NORTH LINCOLNSHIRE GREEN ENERGY PARK EXAMINATION OF DEVELOPMENT CONSENT ORDER EXAMINING AUTHORITY'S FIRST WRITTEN QUESTIONS (EXQ1) WRITTEN RESPONSE ON BEHALF OF AB AGRICULTURAL LIMITED

Planning Inspectorate Ref: EN010116
Interested Party Ref: 20032351

This note has been prepared on behalf of AB Agri Limited in respect of the ExQ1 relative to temporary possession as an Affected Person with regard to Plot No. 5-54 on the Land Plan Sheet No.5.

As per Open Access 2015/15154 - Through ERM Development Support/000 - Drawing/Design for Client Review/31/04/2020/001/NLGP/Works Plans A11.dwg

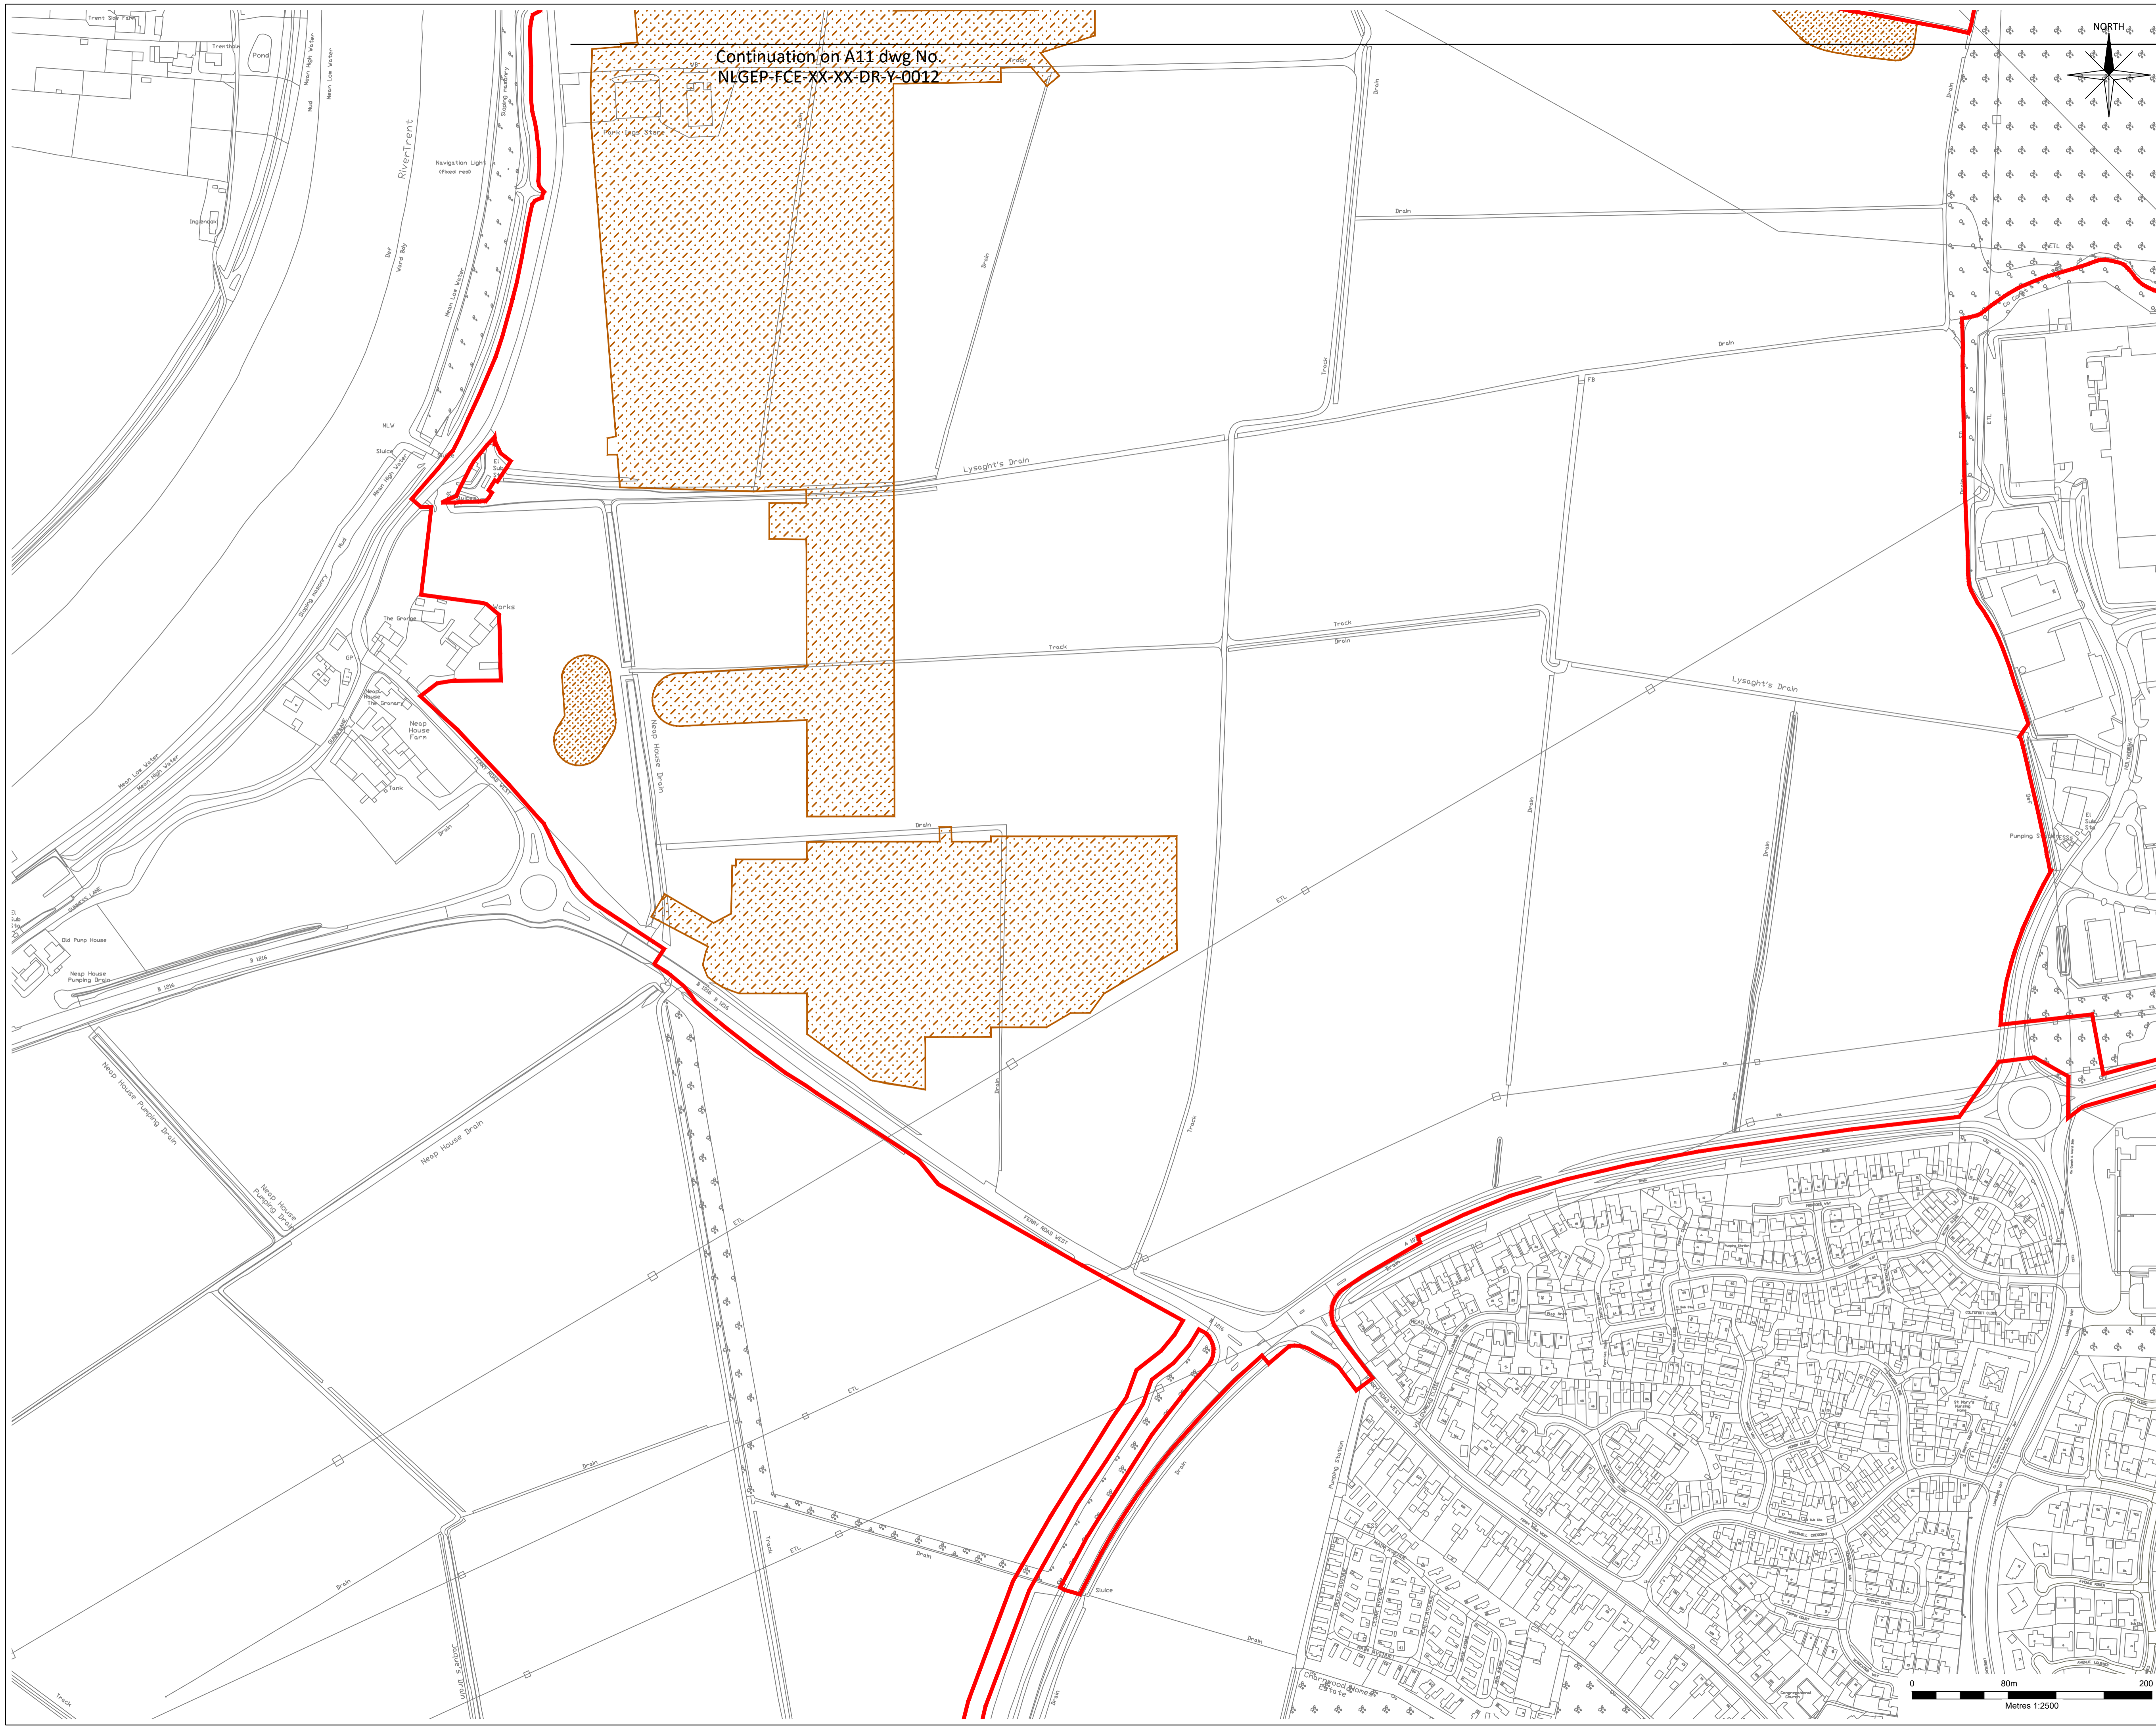
AB Agri's response: The proposed compulsory acquisition of AB Agri's land is for the temporary possession of Plot 5-54 for the purposes of temporary laydown areas as part of the construction of Work Nos. 10 and 11. According to the Applicant's land agent, possession will be needed for 3 years and is specifically required to provide a working area during construction of the flood defence bund. It has since been clarified by the Applicant that Plot 5-54 is required on a temporary basis for carrying out Work No 13 (construction of flood defences) as shown on Works Plan A11 (AS-009) rather than as part of the construction of Work Nos 10 and 11.

Plot 5-54 comprises an approximately 6-metre deep strip of land along the entire 100-metre southern boundary of AB Agri's site and for 60 metres along the western boundary, with the northern-most possession abutting the main entrance to the processing plant.

Possession for three years of approximately one third of the perimeter of the site and one half of its road frontage will significantly compromise AB Agri's enjoyment of its land. Construction works and activities within AB Agri's site in extremely close proximity to the raw material intake of the animal feed production plant will significantly increase the biosecurity risk of the site even with usual construction environmental management plan. Furthermore, the possession will pose a contamination risk from potential airborne contaminants from the construction works and activity, as well as potential ground contamination that could in turn put the viability of the business at risk.

It is understood from the Applicant that the temporary possession is sought on a worst-case basis in the event that the necessary flood defence cannot be constructed from the area outside AB Agri's land. The Applicant has not demonstrated an alternative which avoids the temporary possession of AB Agri's land, such as the construction method or justification why a flood defence would need to be constructed from AB Agri's land. Following the meeting on 9 December 2022, AB Agri is awaiting further information from the Applicant on the proposed temporary possession.
